From: Laura Gibbons
Sent: 18 April 2019 12:06
To: Planning.Responses
Cc: Stuart Corbey
Subject: RE: Please find attached amendment on planning application Ref: LU/59/19/PL

Engineers Comments Regarding Surface Water Drainage

APPLICATION NO: LU/59/19/PL

Registered: 19-FEB-19
Site Address: Land at Watersmead Business Park Worthing Road
Littlehampton BN17 6LS

## **Appendix E – Proposed Drainage Strategy**

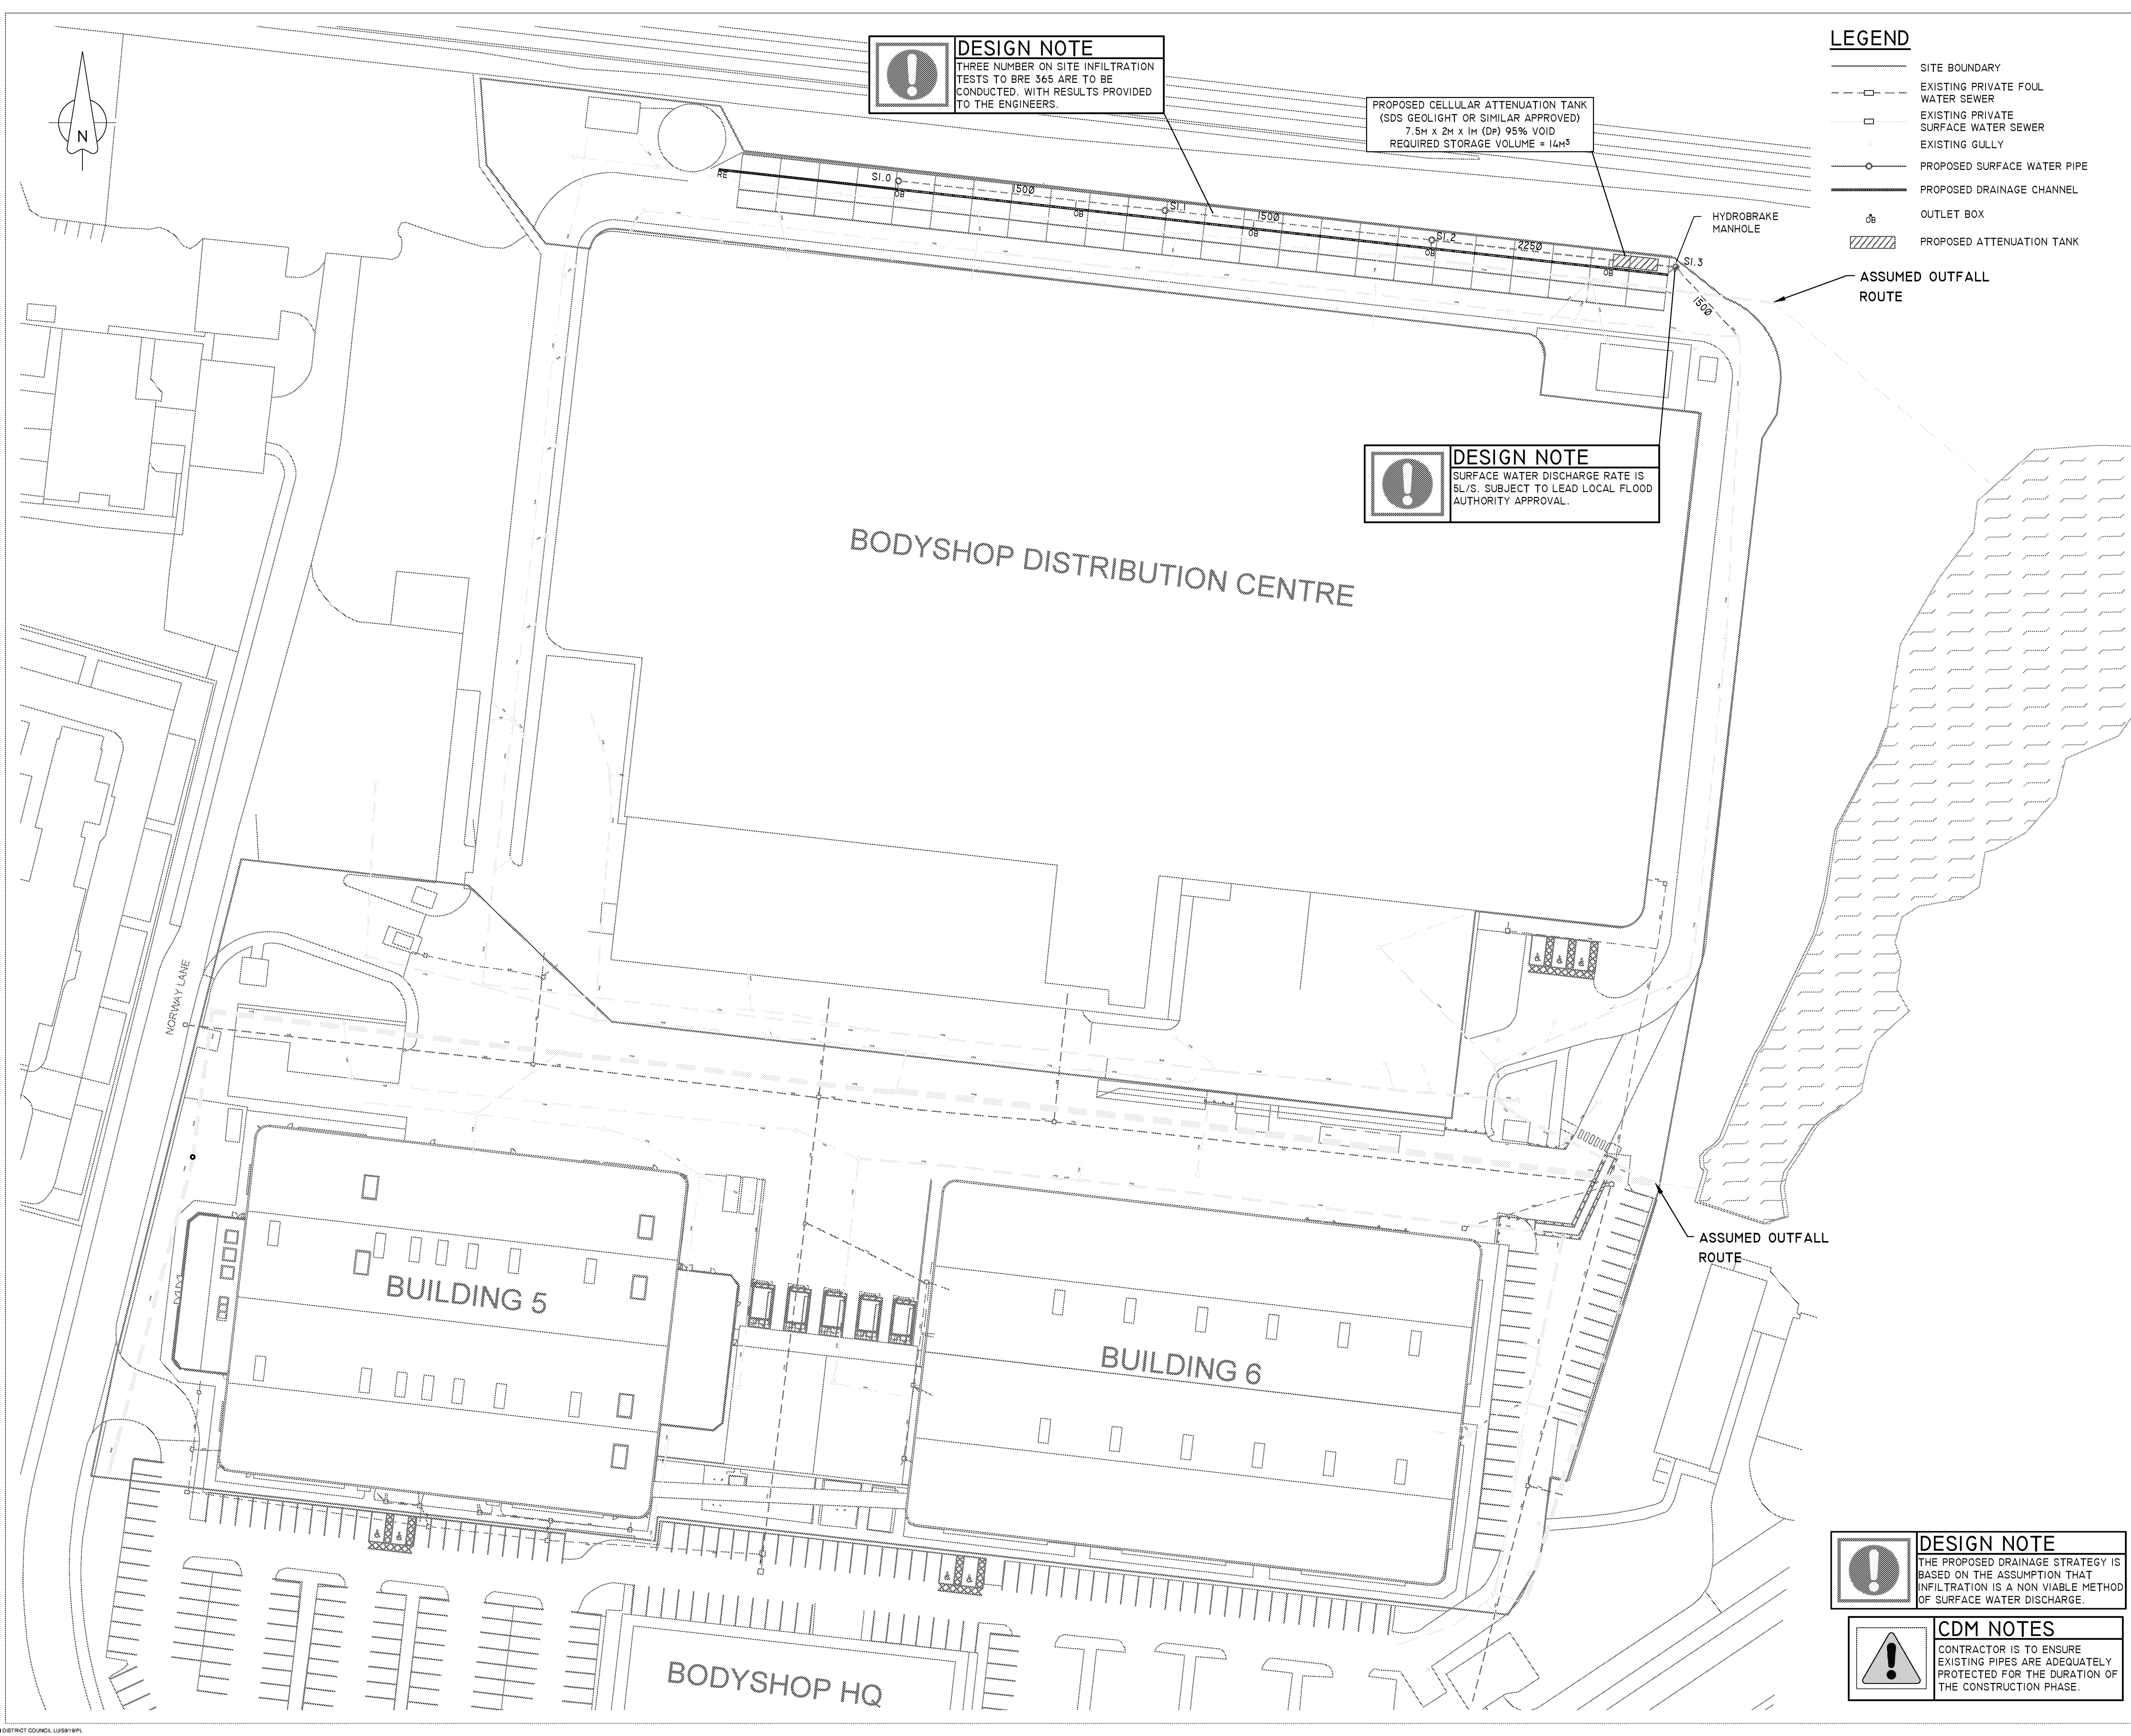
1. The proposals are to attenuate water and discharge at a rate of 5l/s, yet greenfield runoff rates are 0.3l/s. We would require that proposed discharge rates are reduced to 2.5l/s, this rate is achievable without increasing the risk of blockage to unacceptable levels. A hydrobrake with a minimum sump depth of 300mm should be provided.

2. Attenuation volume has been calculated for the 30 year event only. We require that the 30 year plus 40% climate change event is attenuated and it must also be demonstrated that water remains on site for the 1 in 100 year plus 40% climate change event.

4. The proposed attenuation tank appears to clash with the existing surface water drainage network. Clarification must be provided as to how the two will interact. Invert levels and cover levels of the proposed drainage must be provided.

5. Will the proposed drainage channel have a sump?
6. Construction detail drawings need to be provided.
7. Our checklist should be completed and all relevant details submitted as outlined within this.
